DRB Application No.: 07DRB-70308

Project Name: MONKBRIDGE ADDITION tbka TRACTS A & B, NEW MEXICO BANK & TRUST

**CITY OF ALBUQUERQUE
Planning Department
October 17, 2007
DRB COMMENTS**

RE: Lots 5-11 & Portion of 12 & 13-15, Block 17, Monkbridge Addition (TBK Tracts A & B, New Mexico Bank Trust)/p&f

Plat of
Tracts "A" and "B"
**New Mexico Bank
and Trust**
Albuquerque, Bernalillo County, New Mexico
October 2007

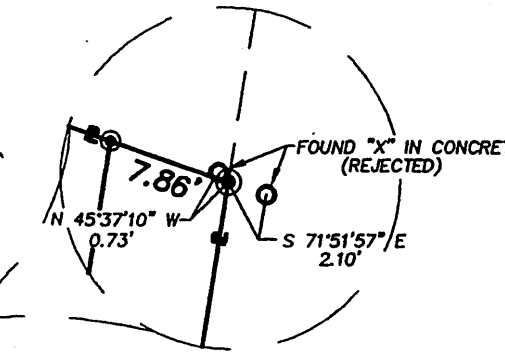
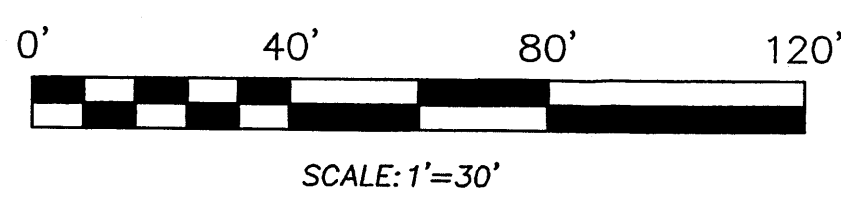
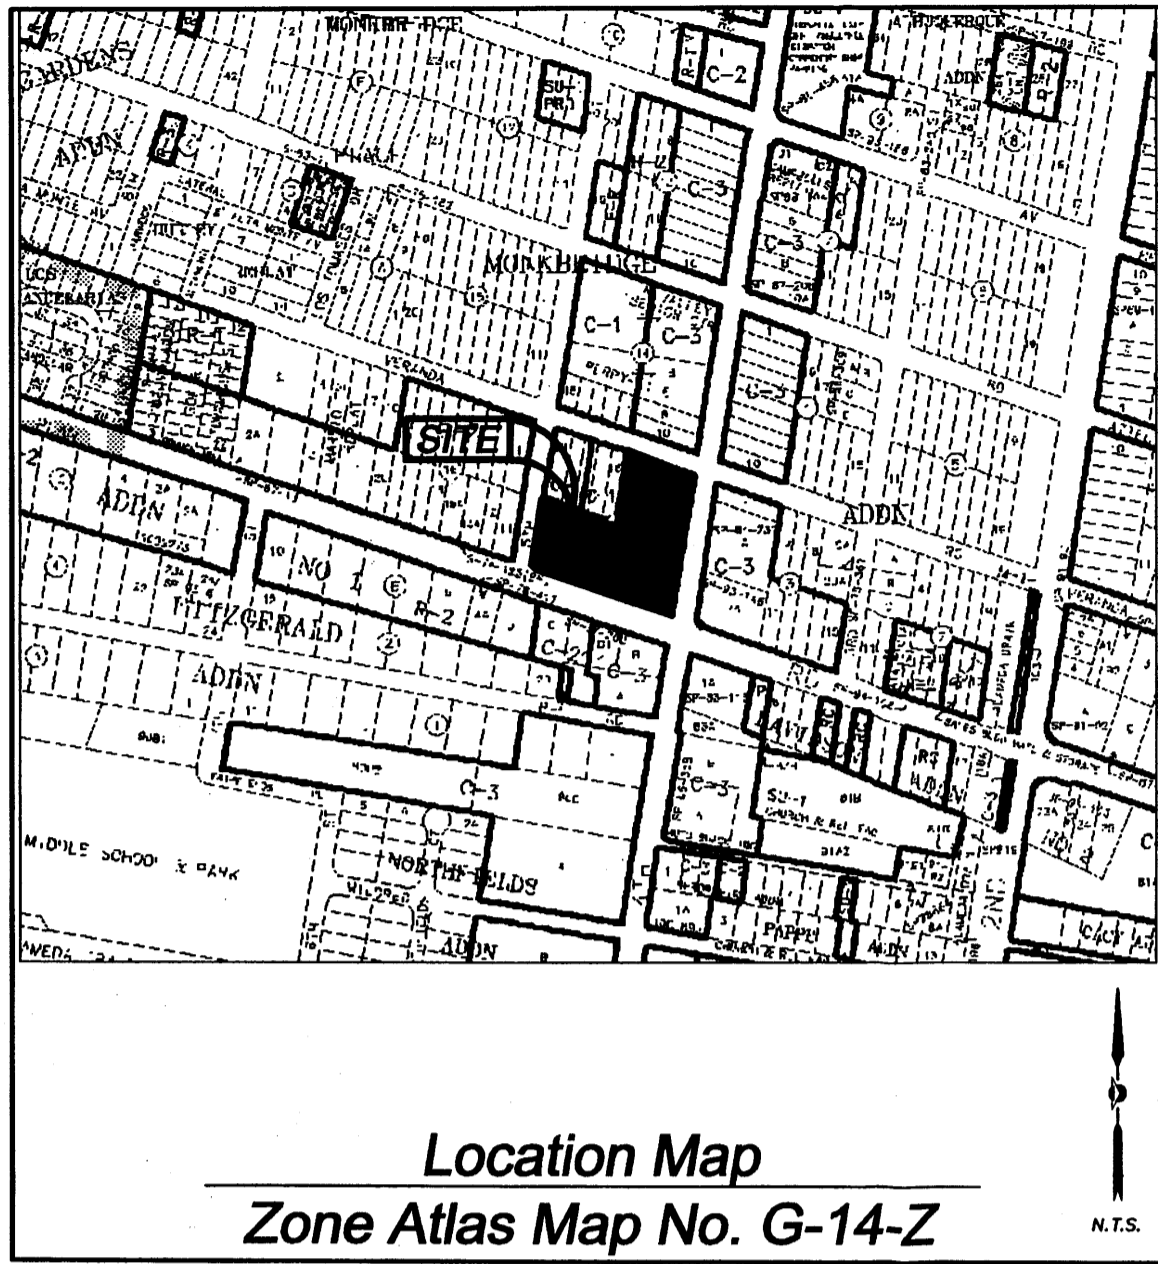
There are two different zone categories on tract B, P and C-1. The P zone line needs to be corrected to remain consistent with the designated zone area as identified on the AGIS map.

The AGIS dxf is not approved.

Please be advised that any plats approved by DRB must contain the following language per the City Subdivision Ordinance:

Section 14-14-4-7(B) "No property within the area of requested final action shall at any time be subject to a deed restriction, covenant, or building agreement prohibiting solar collectors from being installed on buildings or erected on the lots or parcels within the area of proposed plat. The foregoing requirement shall be a condition to approval of this plat or site development plan for subdivision."

Planning will take delegation for the Solar collector language, the AGIS dxf, to record the plat, and to correct the P zone line.
